COLORADO
Department of Transportation

December 13, 2023

SH24 / SH94 / Marksheffel
El Paso County

RE: Crossroads North Preliminary Plan - SP207

CROSSROADS NORTH
EARLY GRADING & EROSION CONTROL PLANS
PROJECT NO. 18-006
SCALE: HORIZONTAL: N/A
VERTICAL: N/A
DATE: 08/29/2023
DESIGNED BY: DM
DRAWN BY: GT
CHECKED BY: VAS
SHEET 2 OF 15
EGRO1A

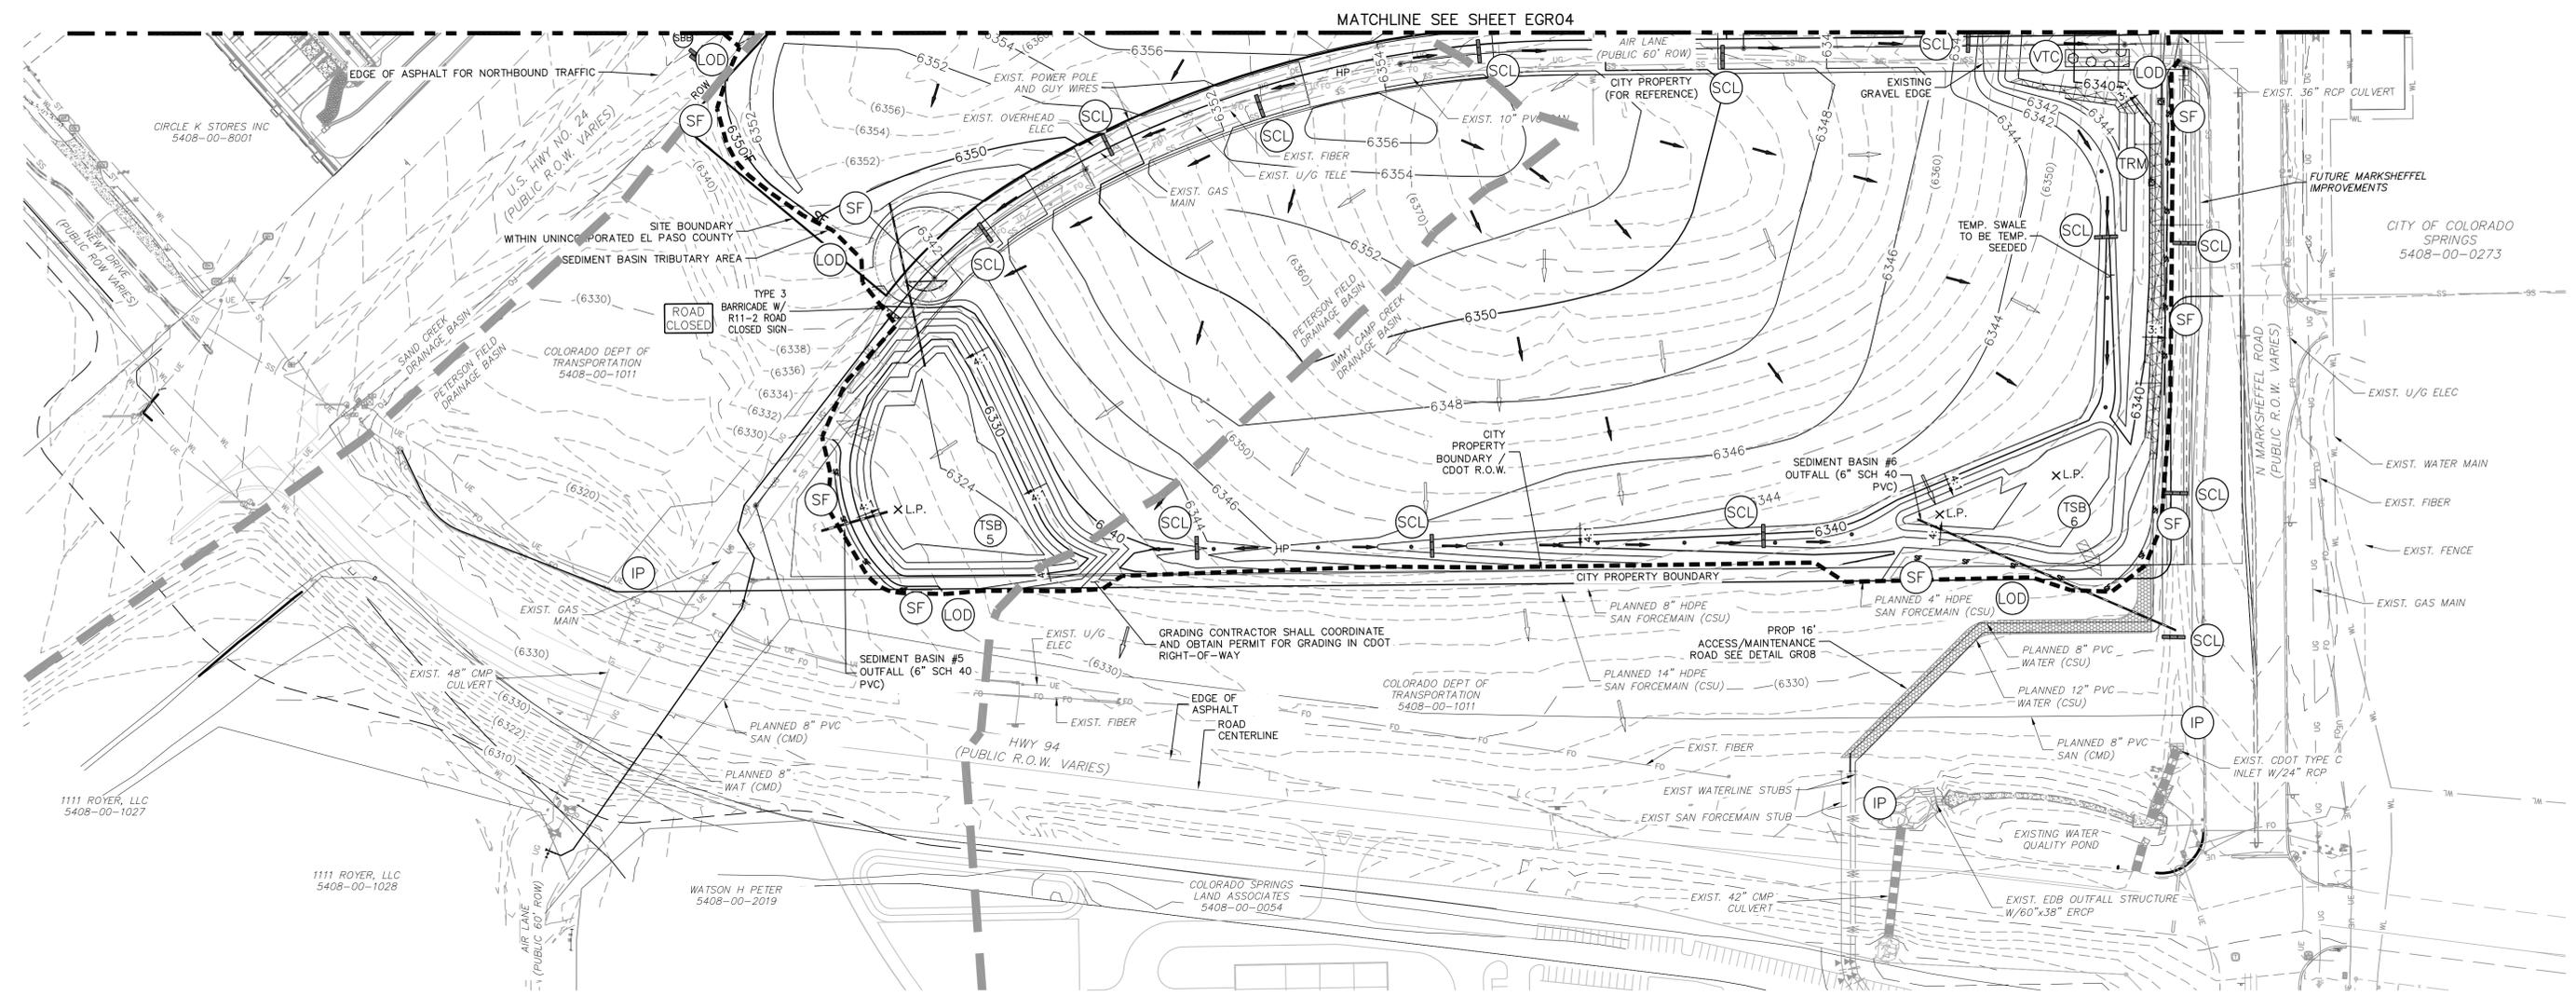
- There does not appear to be any impacts to CDOT ROW. The early grading plan is draining away from SH24.
- It appears there may be utility conflicts at the proposed storm line at design point 32 (northeast corner of intersection of 24 and 94).
- Note that Highway 24 will be widened in this section in the future. Refer developer to the US24 PEL here... <https://www.codot.gov/projects/archived-project-sites/us-24-pel-study>
